Your Ref: 3/2023/0156  
PR3 2TH

Planning Application No: 3/2023/0156 - Dog and Partridge conversion  
Hesketh Lane, Chipping, PR3 2TH.

Below are comments relating to application 3/2023/0156 relating to the conversion and extension of the former Dog and Partridge.

Title: **DIVERSION OF SW DRAIN AND ABANDONMENT OF EXISTING FW DRAINS**

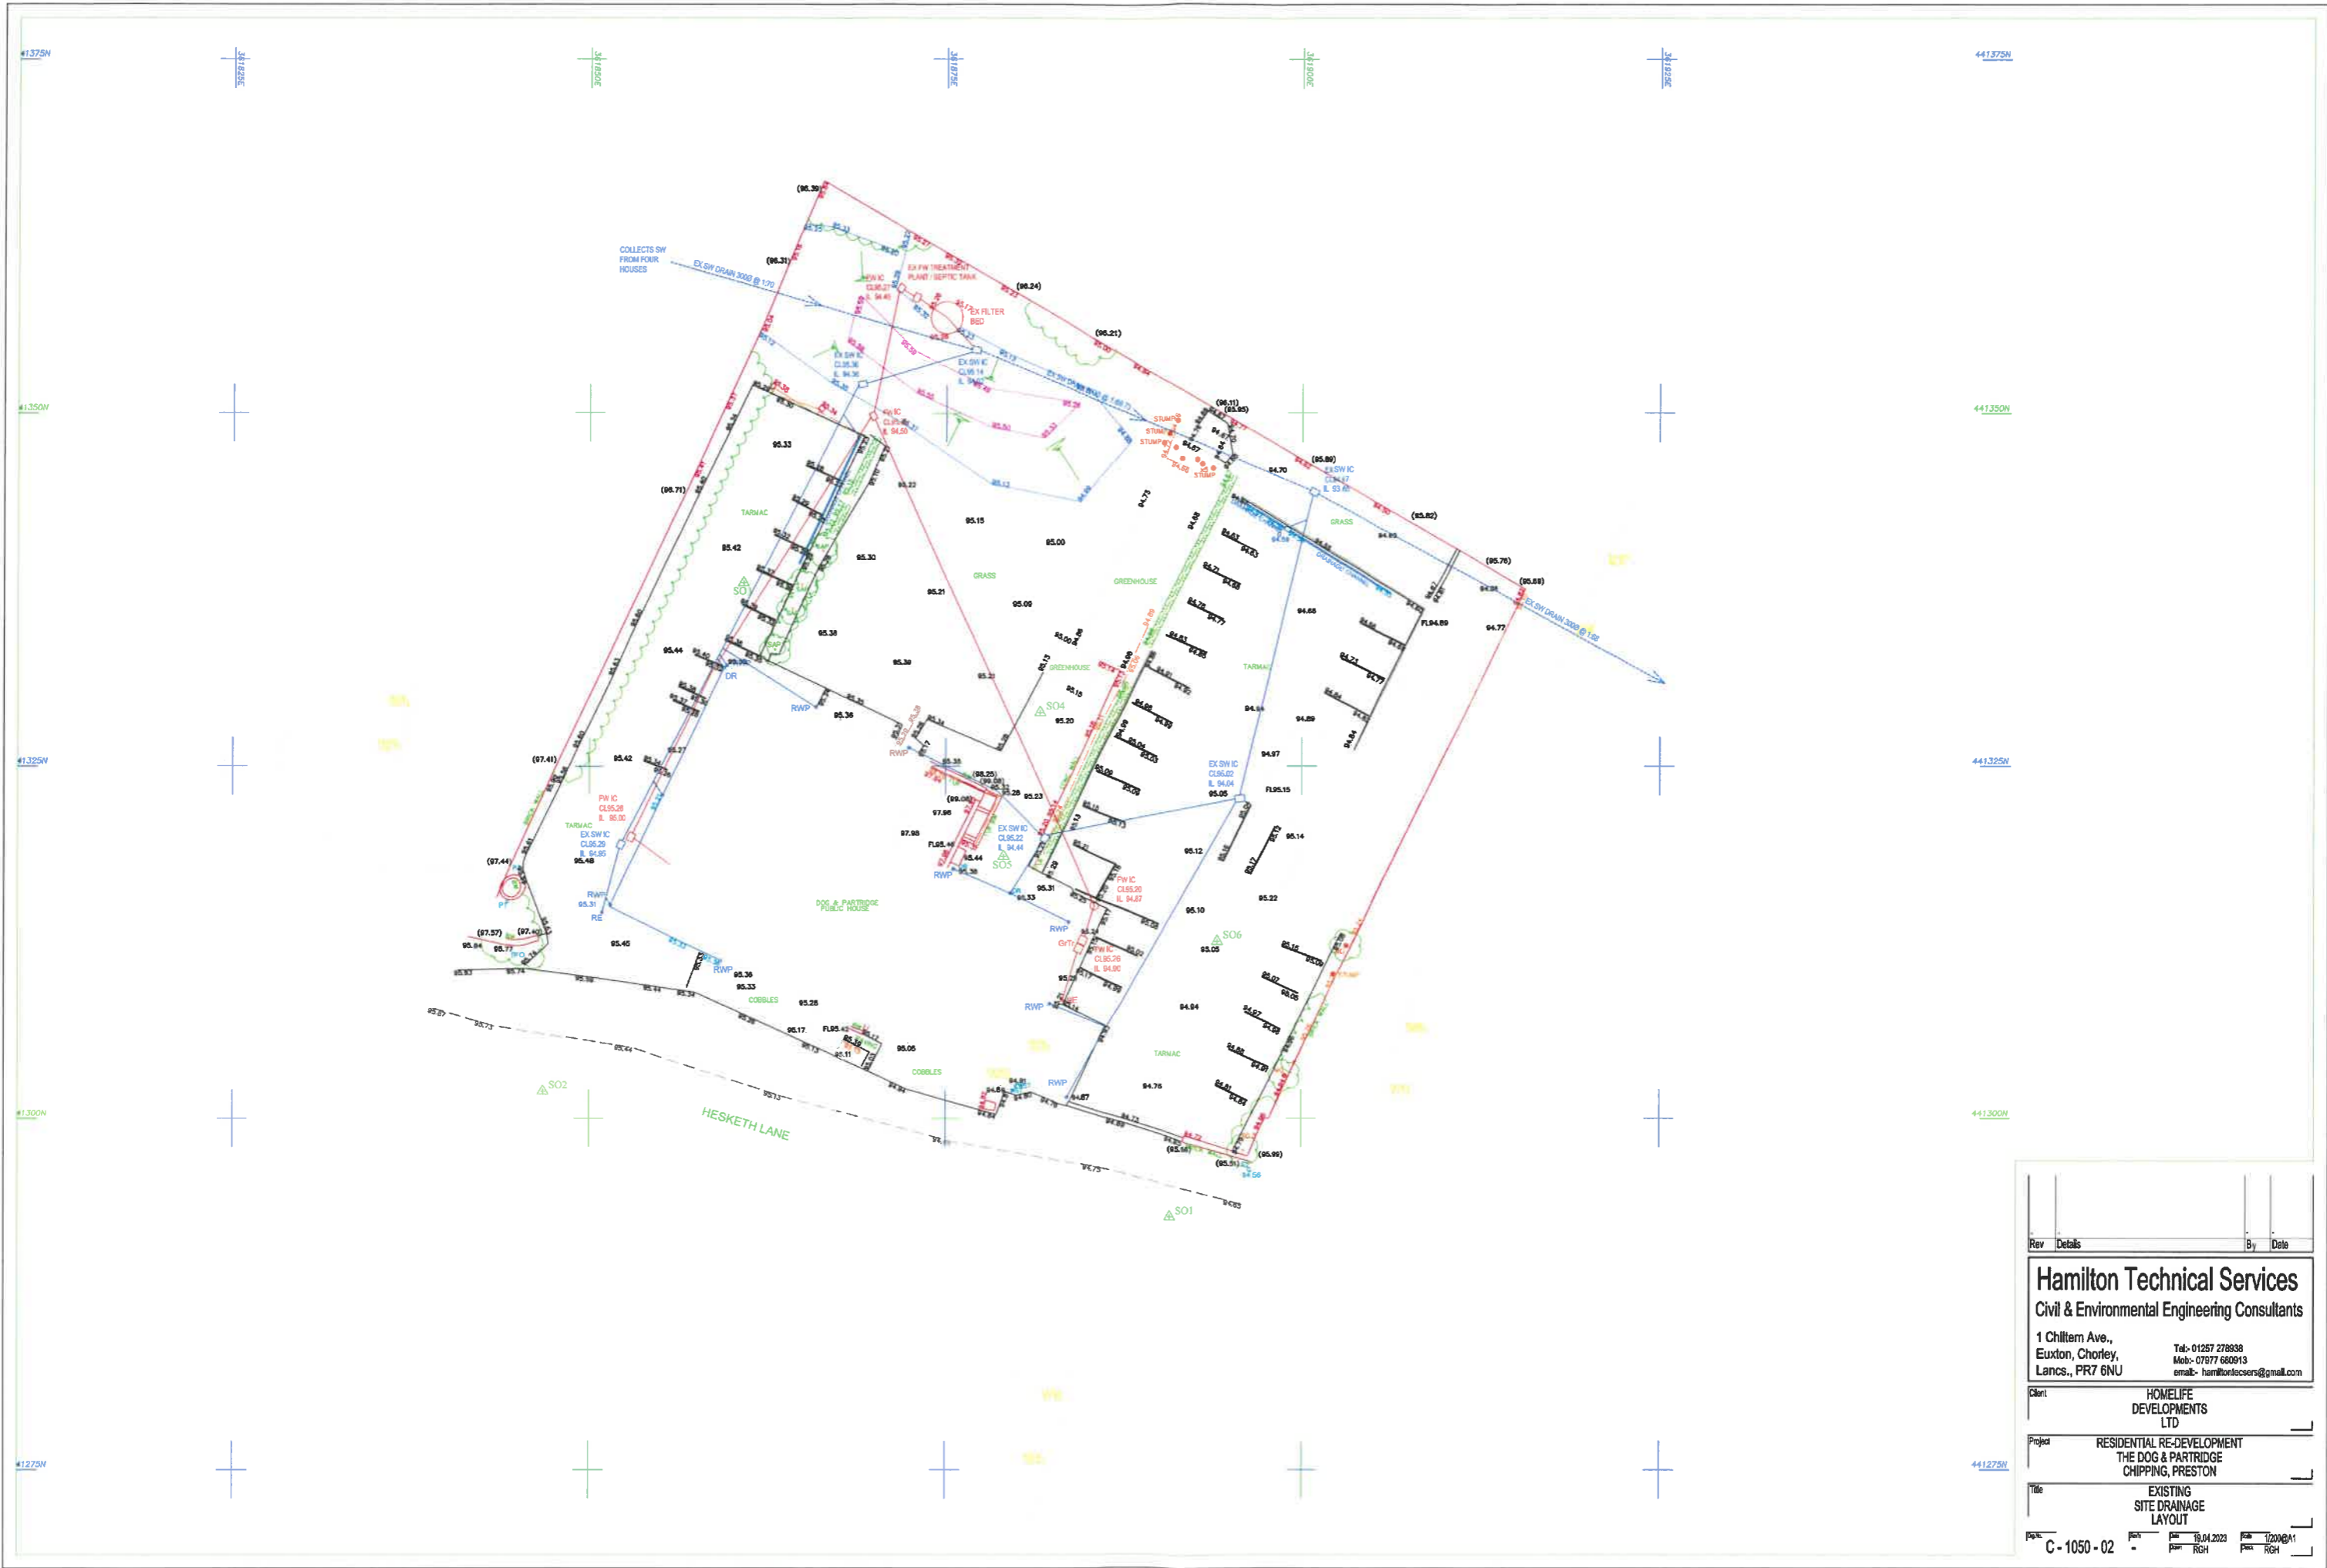
1. I note it is the proposal/intention of the applicant to alter the line of the existing foul water/surface water drain, which, according to the revised plans would run under the four proposed holiday lets. It should be noted this drain belongs to and is used by the properties of the five houses situated to the west of the proposed development. [REDACTED] residents of these properties have maintained, paid for, any remedial works that have been required to this surface water/foul water drain. As far as I am aware at no time has the developer of the Dog and Partridge been to see, ask for [REDACTED] permission or comments regarding this drain alteration. As it does not affect the Dog and Partridge, but all five properties to the west I would have thought [REDACTED] comments should have been taken into consideration before any plans were submitted. [REDACTED] existing interests in this drainage should be protected.

2. The fact that it is the intention to put a right hand bend in the pipe within the curtilage of the existing Dog and Partridge, appears to be quite a sharp right hand bend, also concerns me. At present the flow down the pipe creates no problem for the highway or the landowners, however in periods of extremely heavy rainfall, which is more likely in the winter months then having another bend in the pipe could cause problems [REDACTED] further up the Lane, meaning foul water, surface water could not run freely.. At present it should be noted [REDACTED] have no such problems.

On the westerly side of the Dog and Partridge site close to the boundary with Hesketh Lane there is a presumed surface water drainage pipe that discharges across the driveway of the proposed new garage. The location of this is not clear, nor the plan for it, on the proposed drainage layout submitted. We would like to ask for appropriate plans for the management of this water drainage pipe to be made.
